**Re: 4001 West Mercer Short Plat
SUB21-002**

Please consider this as a written response to the City of Mercer Island first review comments dated September 14, 2021.

RE: Request for Information #1 for File No. SUB21-002 – Angiuli Pacific Res Trust Short Subdivision 4001 West Mercer Way, Mercer Island, WA 98040; King County Tax Parcel # 362350-0365

SHEET  
6 OF 9

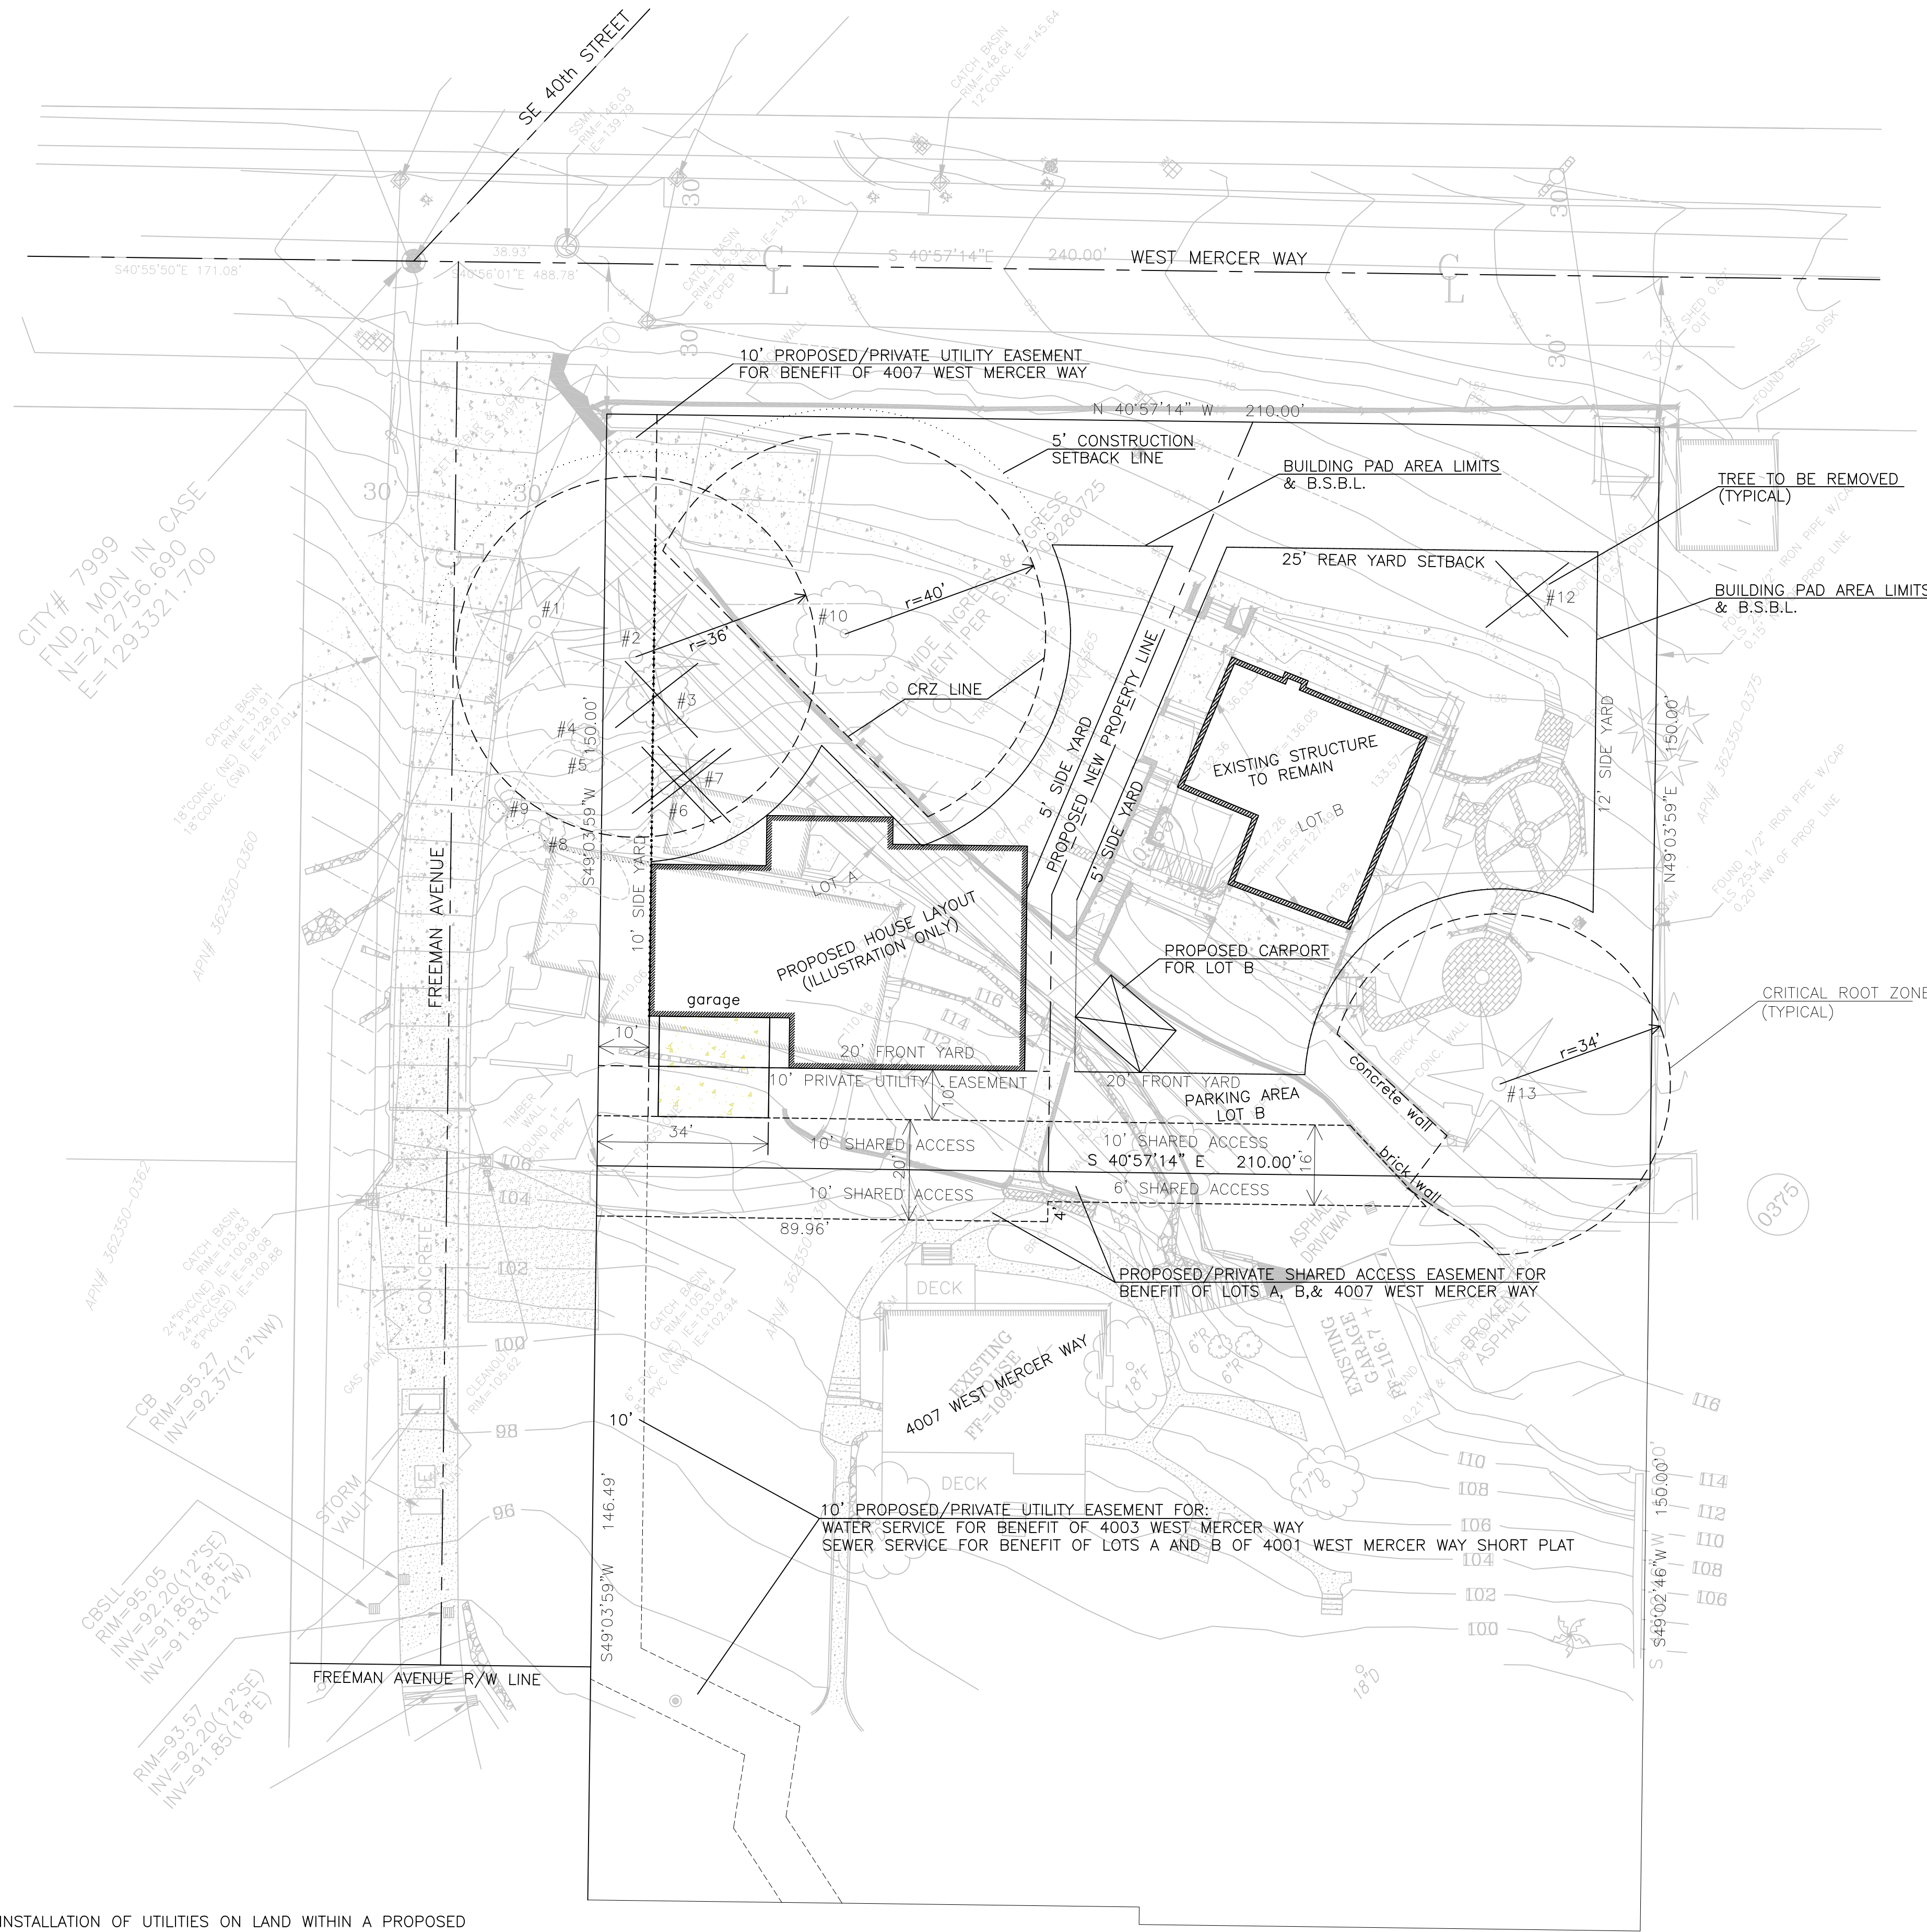
- a. Please illustrate the two (2) building pad areas that comply with MICC 19.09.090. In general, the building pad excludes setbacks and avoids and minimizes impacts to the following: trees (such as tree 13), vegetation, topography, and critical areas (geohazards). **Building pads are shown on Sheet 6 of 9, Development Plan Set**

- f. Illustrate the proposed driveway and building footprint location on Lot A. The proposed driveway location will impact the net lot area. **Shown on Sheet 6 of 9 of Development Plan Set**

- j. For Lot B provide the old lot slope, net lot area, lot area, lot coverage, hardscape, gross floor area (GFA), parking, impervious surface, lot width and lot depth. **Lot B information has been updated on Sheet 6 of 9**

- l. Since a new shared access easement is proposed on the lot to the south at 4007 West Mercer Way, please note the net lot area for 4007 West Mercer Way. The city needs confirmation that the net lot area for this property complies with the minimum net lot area standards because it is being altered by the proposed subdivision. To calculate the net lot area 100% of the shared access easement area on must be excluded from the lot area as the entire easement on the property is used to access the existing garage at 4007 WMW. **Information regarding 4007 West Mercer Way can be found on Sheet 6 of 9, net area, impervious coverage, etc.**

11. Page 6 of 9: Is this the Right-of-Way (ROW) limit? Please label. **called out on Sheet 6 of 9**

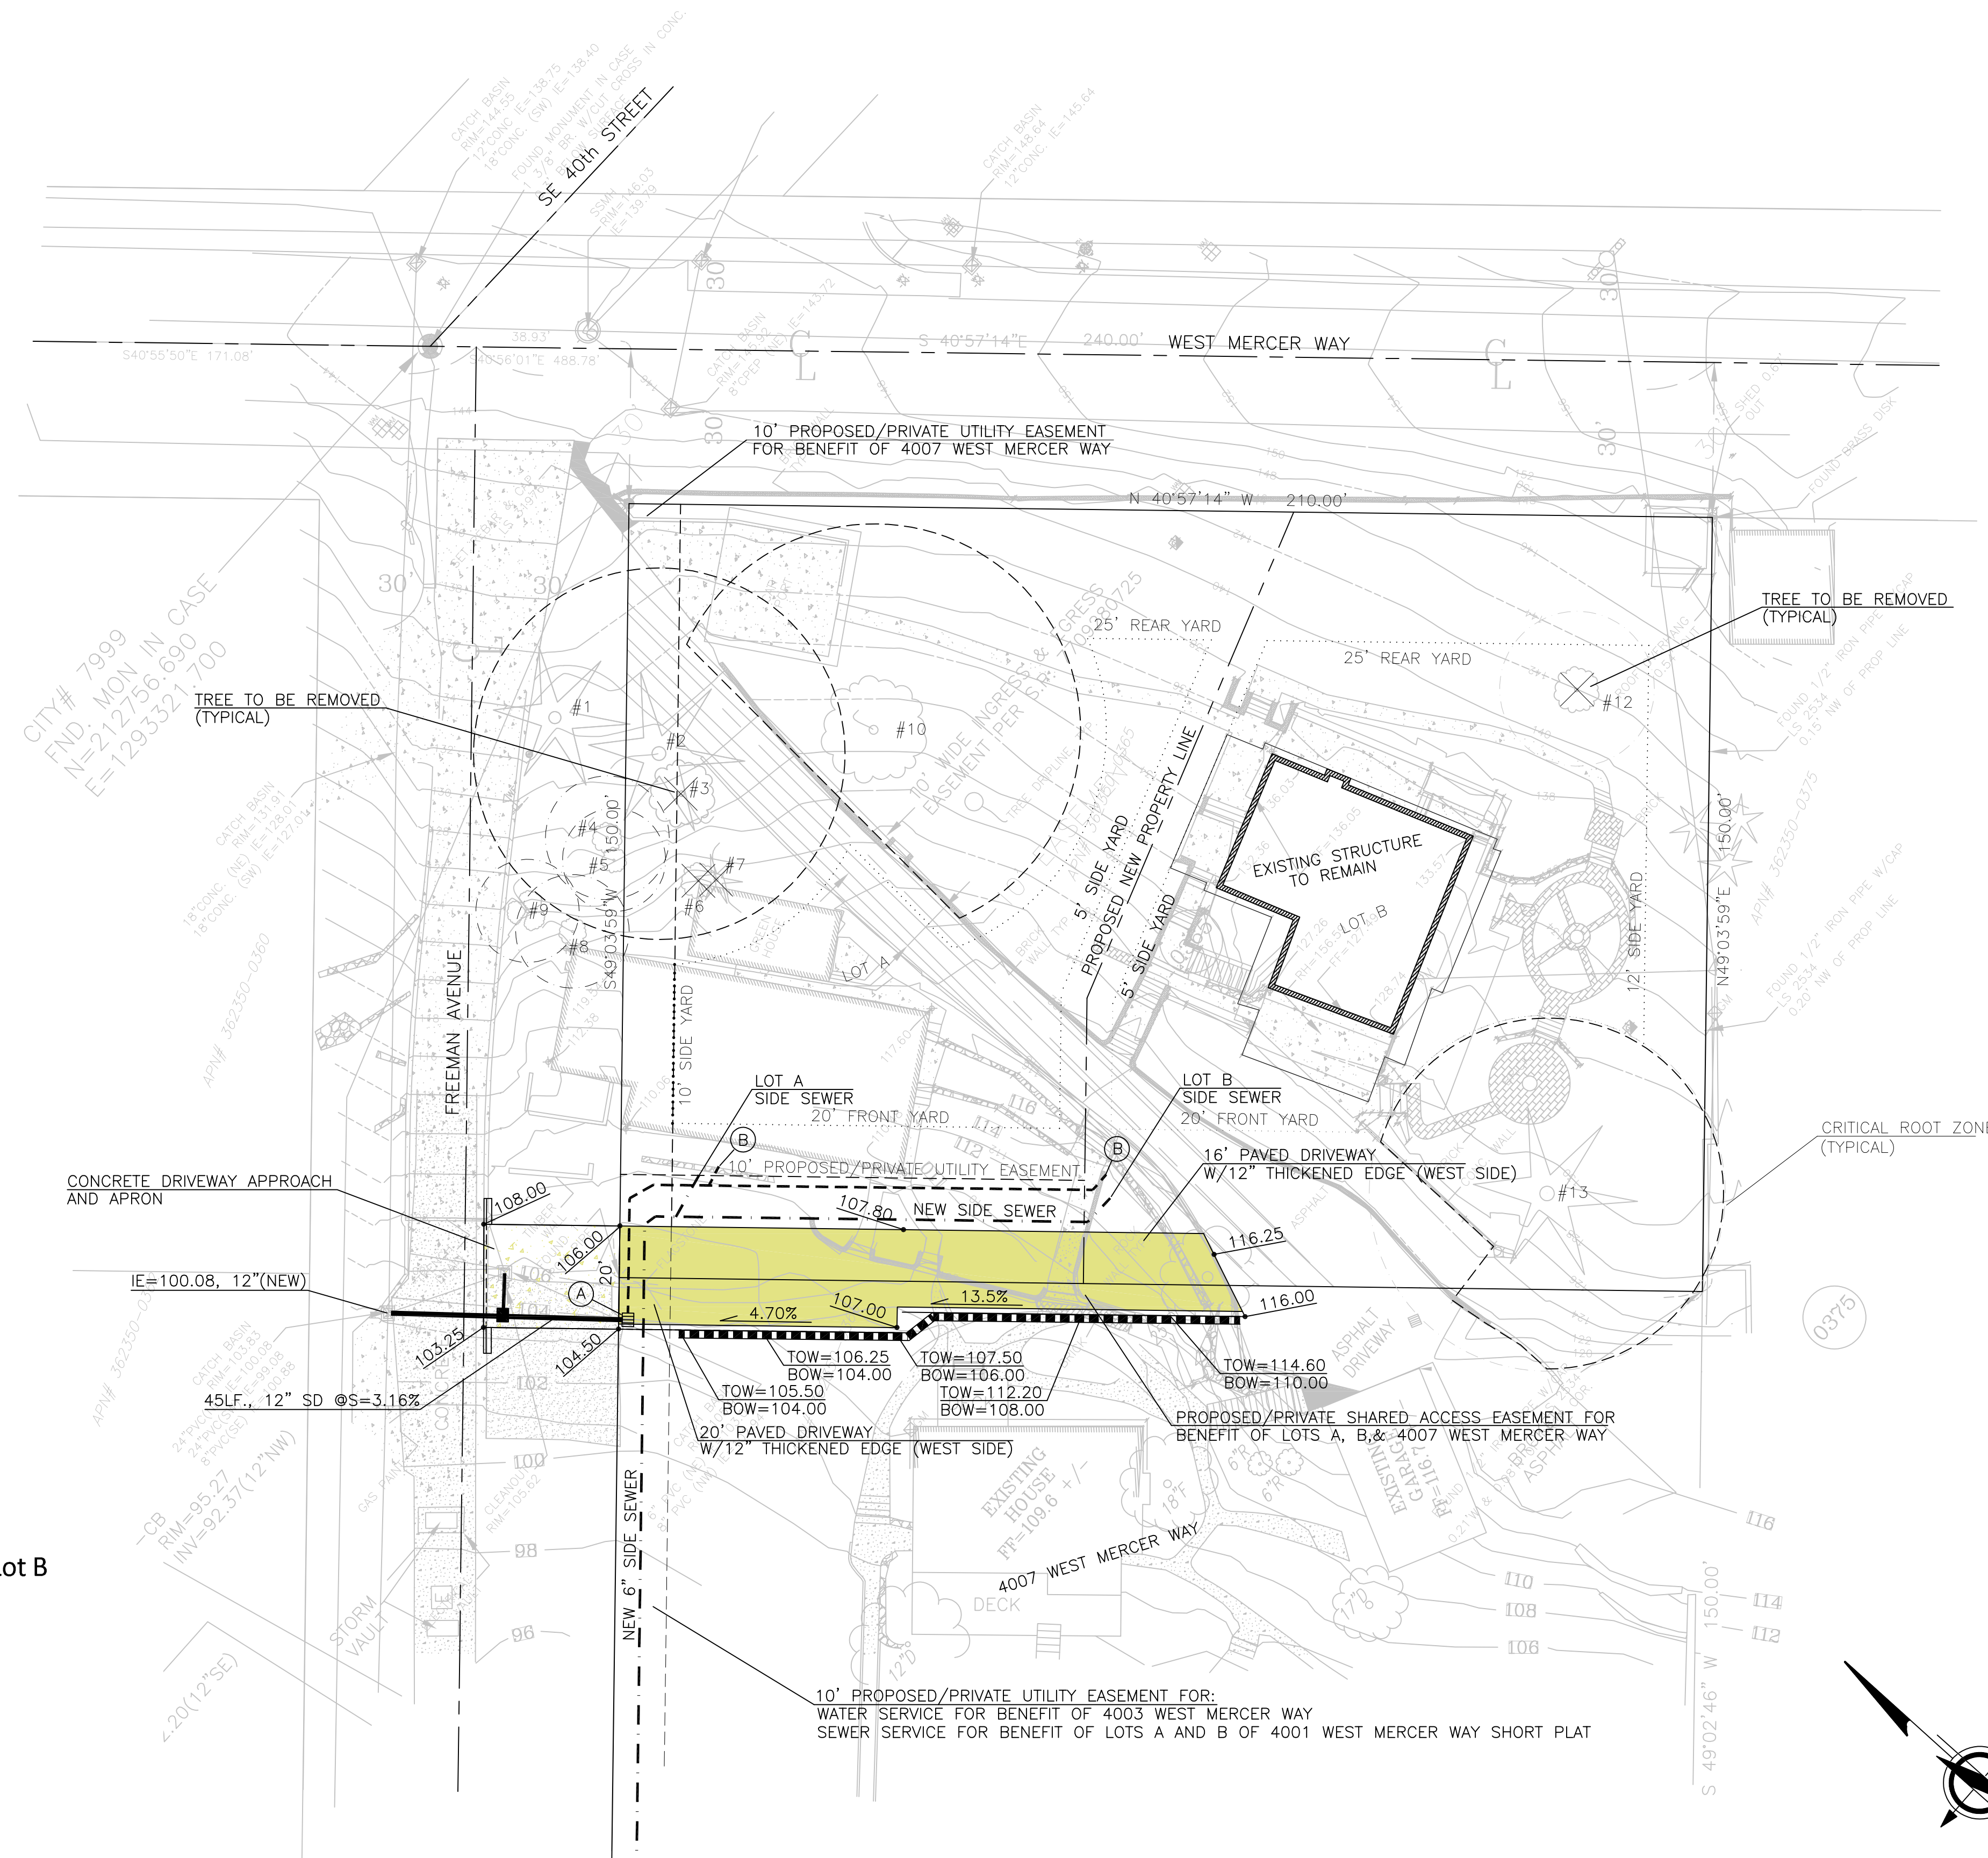
- h. Note Lot A’s southern property line dimension. **Property line dimension called out on Short Plat map and Development Plan Set, sheet 6 of 9.**
- i. Page 6 of 9: Where on Lot A are the 2 covered parking stalls? Are the buildings on Lot A proposed to be demolished or remain? **See Sheet 7 of 9 for location of existing carport to be removed**

- k. Page 7 of 9: there is a note that states the following “existing impervious surfaces to be removed under separate demo permit, typical.” When do you plan on submitting the demo permit? Below are the two options moving forward: **Noted**
